Your ref: SSD 5175 MOD 2
Our ref: MC-12-1769

Section 96(2) modification request to amend the indicative concept plan, urban design guidelines and permitted uses for the Eastern Creek Business Hub

Issues for consideration – SSD 5175 MOD 2 for the 'Eastern Creek Business Hub'

Figure 52: Development Control Plan - Lot 2 (not to scale)

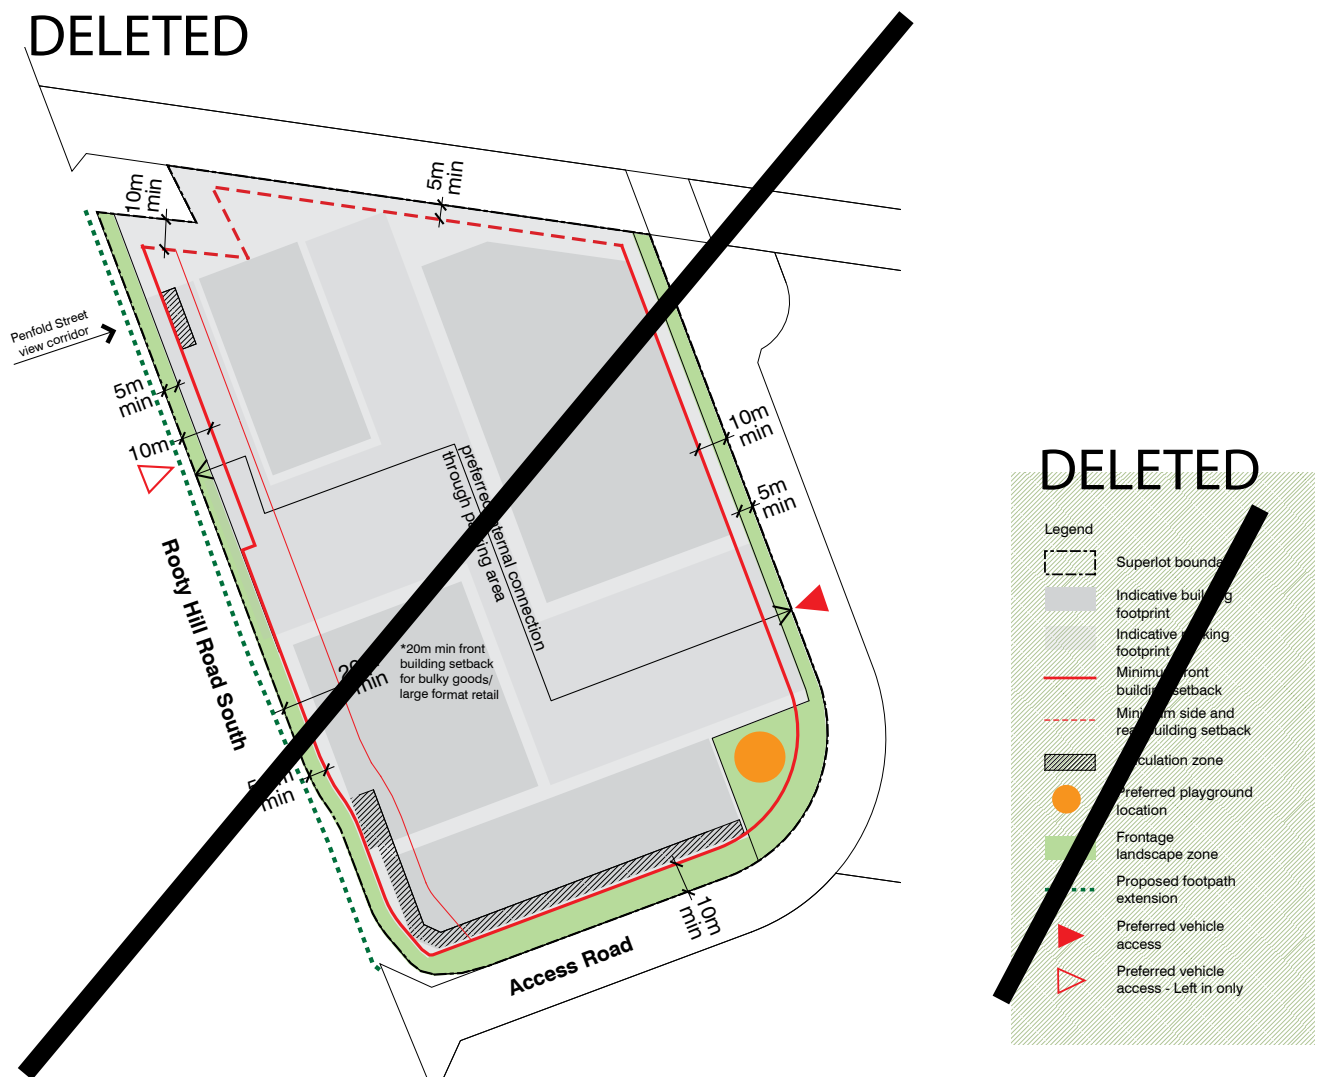
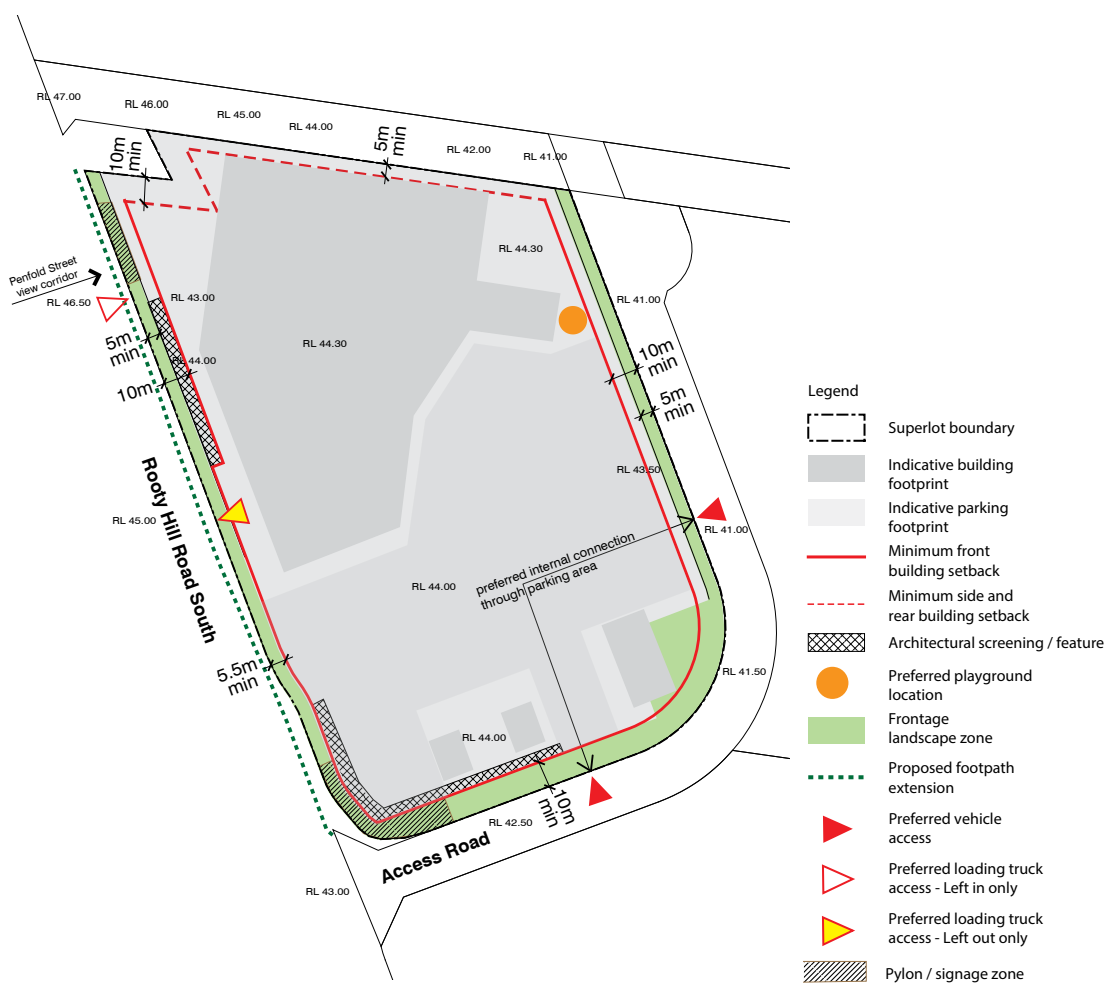
- Control C2 requires that the loading areas are to be located behind the front building line. The proposed structure plan does not achieve this. The plan and design guidelines should be updated to provide a more appropriately located loading dock, which address the concerns outlined above.

- C1 is to be updated to require a 10 m building setback to Rooty Hill Road South.
- C5 is to be updated to require a minimum 5 m landscape setback to the car parking area adjoining the internal access road.
